SUBJECT: TALLAWANG SOLAR FARM (SSD-23700028)

Thank you for providing Mid-Western Regional Council (Council) with the opportunity to provide comment on the Environmental Impact Statement (EIS) for Tallawang Solar Farm (SSD-23700028). Council has reviewed the documents and wishes to lodge an objection to the application.

FIGURE 1.4

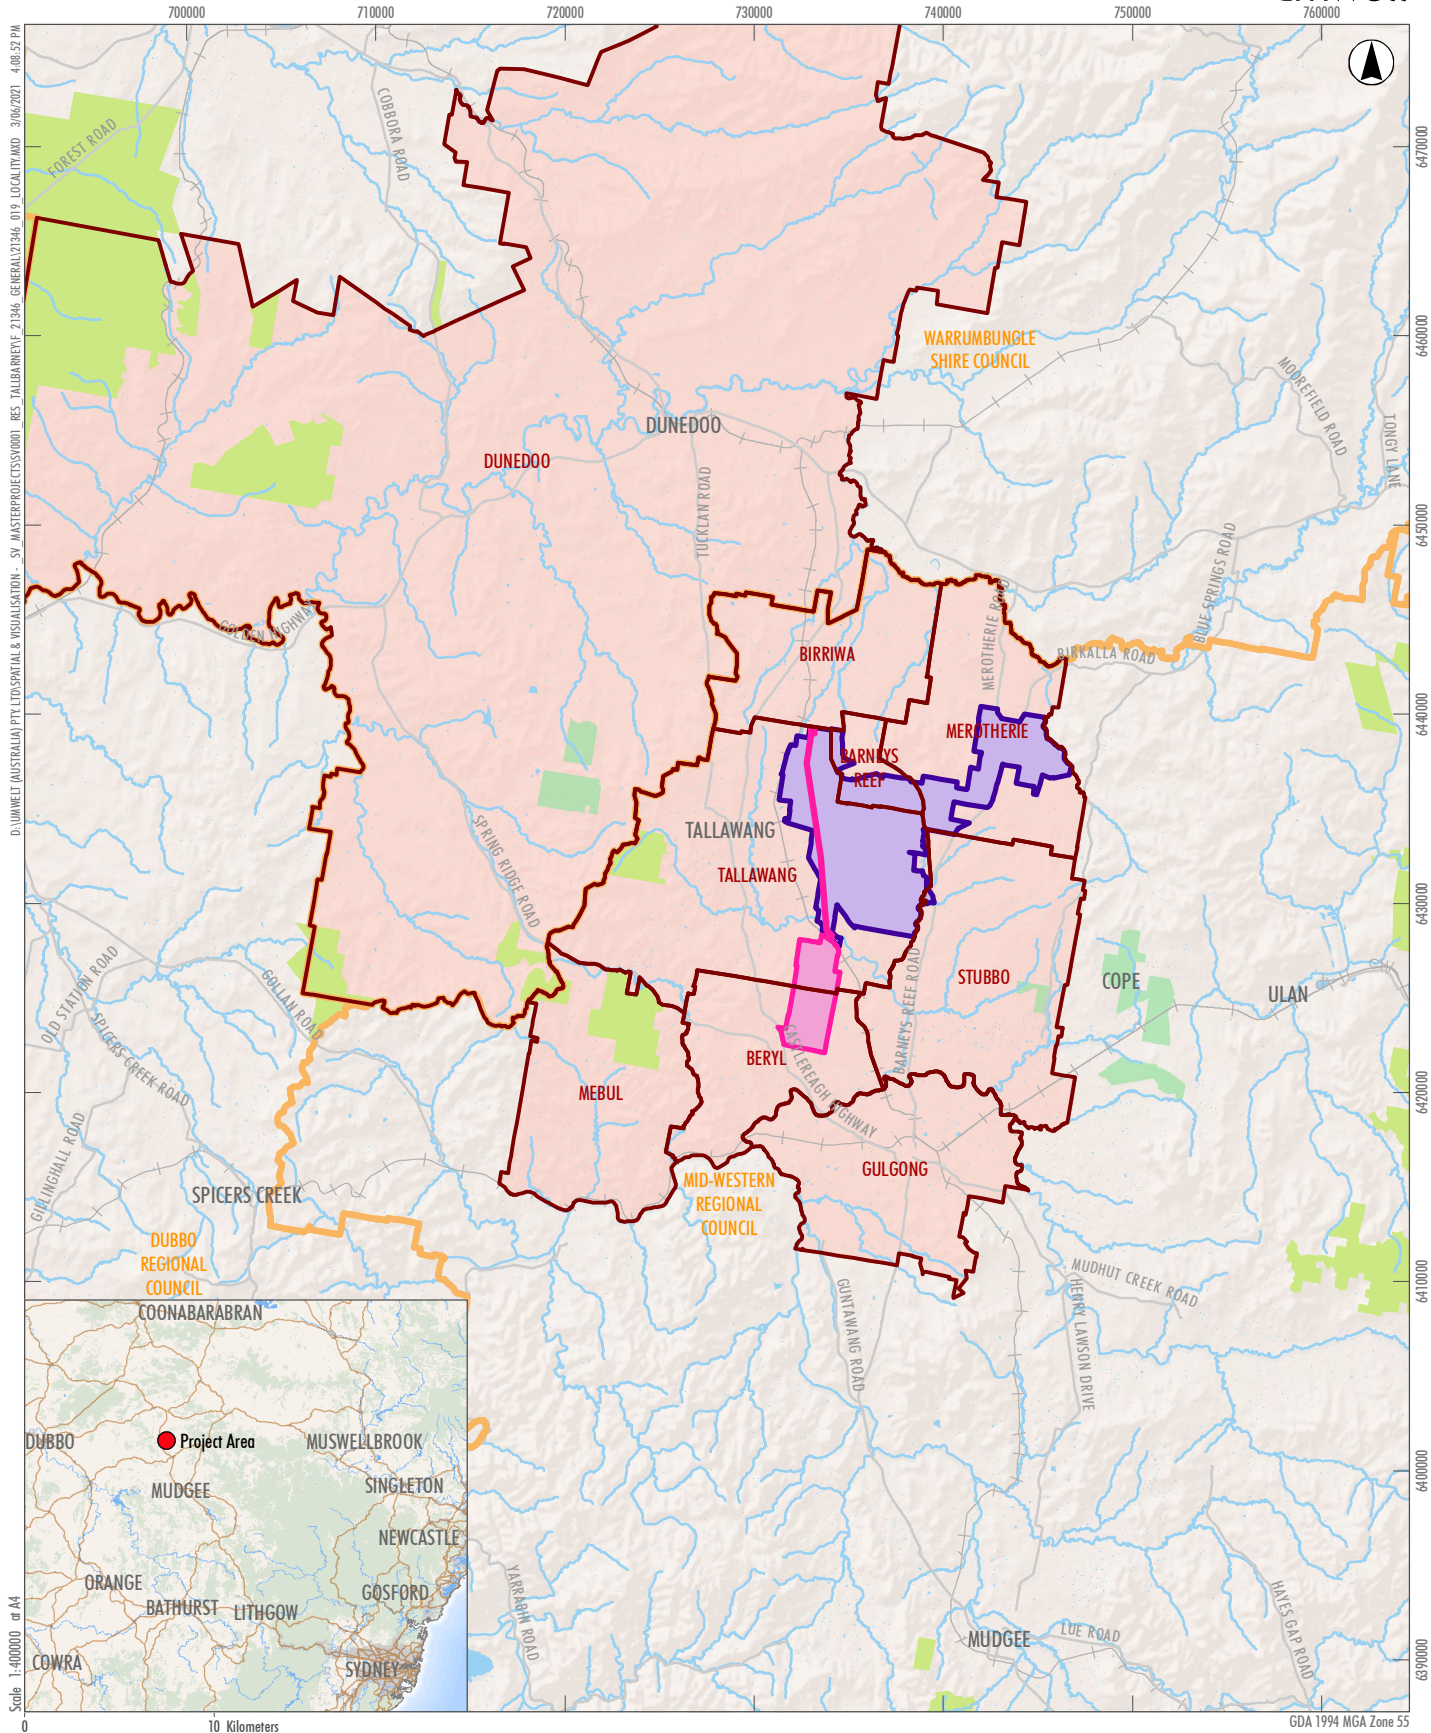
- Council request the proponent revise the SIA to include both Mudgee and Dubbo within the projects identified area of social influence. These areas are included in the Economic Impact Assessment and will be socially impacted due to the proposal of workforce and accommodation to be based in these towns.
